**Subject: 185 Fore Street  
Preliminary Site Plan and Subdivision Application  
Response to Review Comments**

On behalf of Bateman Partners, LLC, we are pleased to provide the following responses to the Preliminary Review Comments related to the Subdivision and Site Plan Application for the proposed proposed mixed-use building at 185 Fore Street. For ease of reference we have repeated the comments in *italics*, followed by our response.

**COMMENTS FROM DAVID SENUS & ASHLEY AUGER, WOODARD & CURRAN  
DATED 05-29-14**

(A) BRICK SIDEWALK DETAIL
N.T.S.

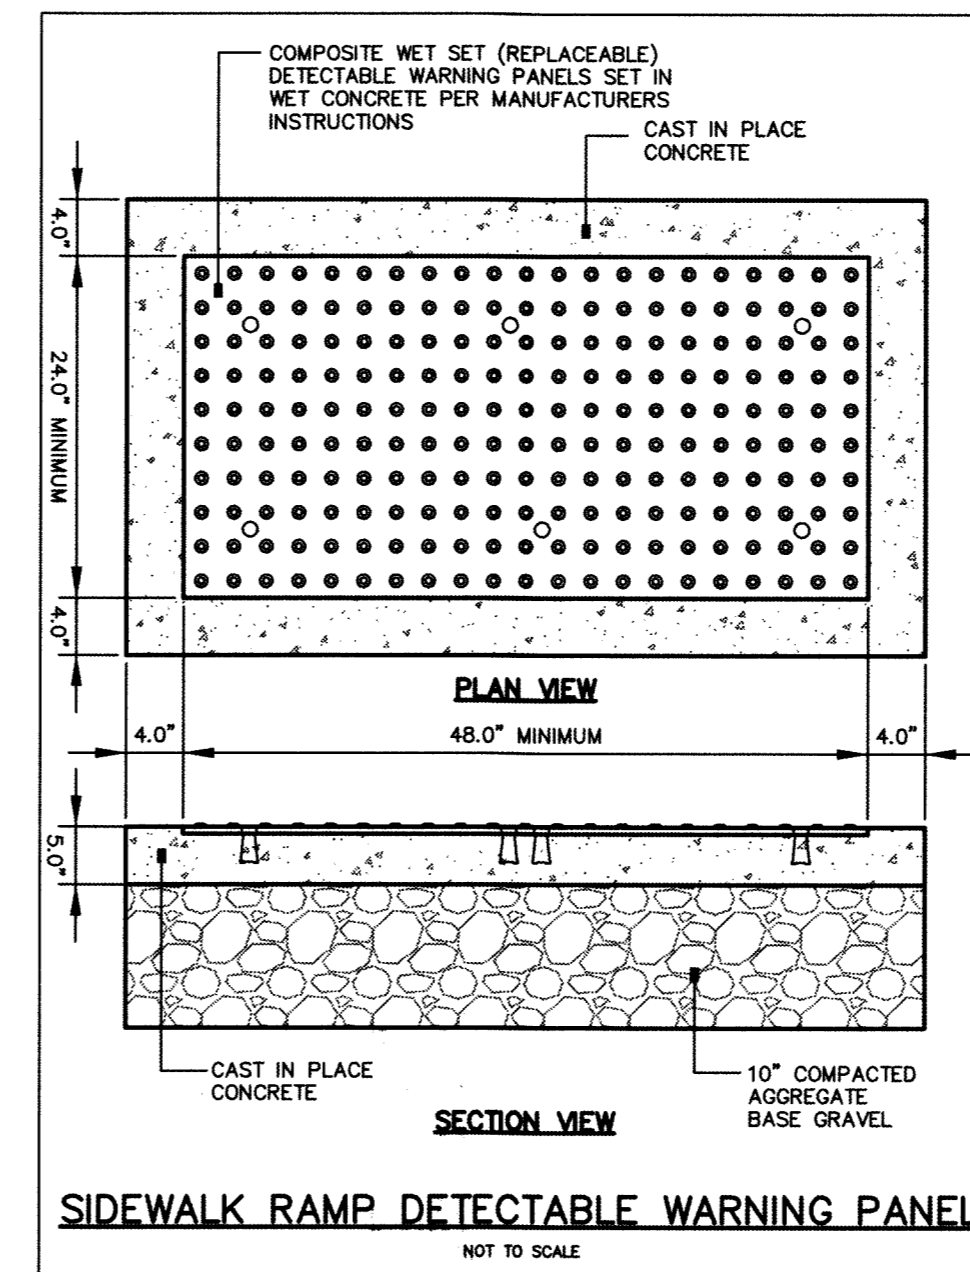
*The Brick Sidewalk, Vertical Granite Curb, and Typical Trench Details should be prepared in accordance with Figures I-10, I-16, and II-12, respectively, of the City of Portland Technical Manual for work within the City Right-of-Way.*

As requested, the City's standard details for brick sidewalk, vertical granite curb and typical trench details have been added to the plan set. A copy of the updated plan set is appended to this comment response letter.

(F) BARRIER FREE RAMP DETAILS
N.T.S.

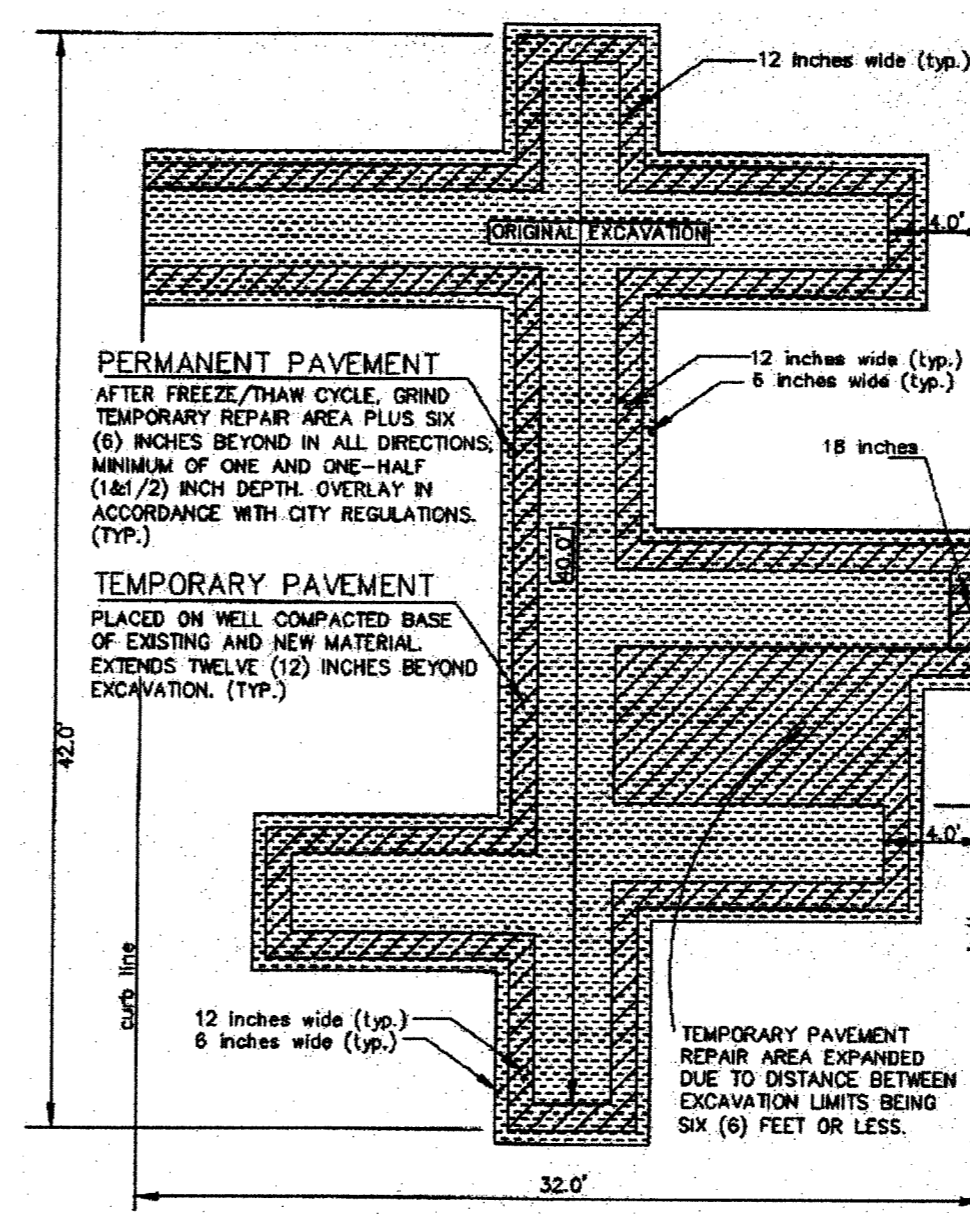
*The Barrier Free Ramp Detail contains a note referencing the Town of Scarborough Right-of-Way; the Applicant should modify this note.*

The barrier free ramp detail has been revised to reflect the City's standard detail sidewalk ramps and detectable warning surface. A copy of the updated plan set is appended to this comment response letter.
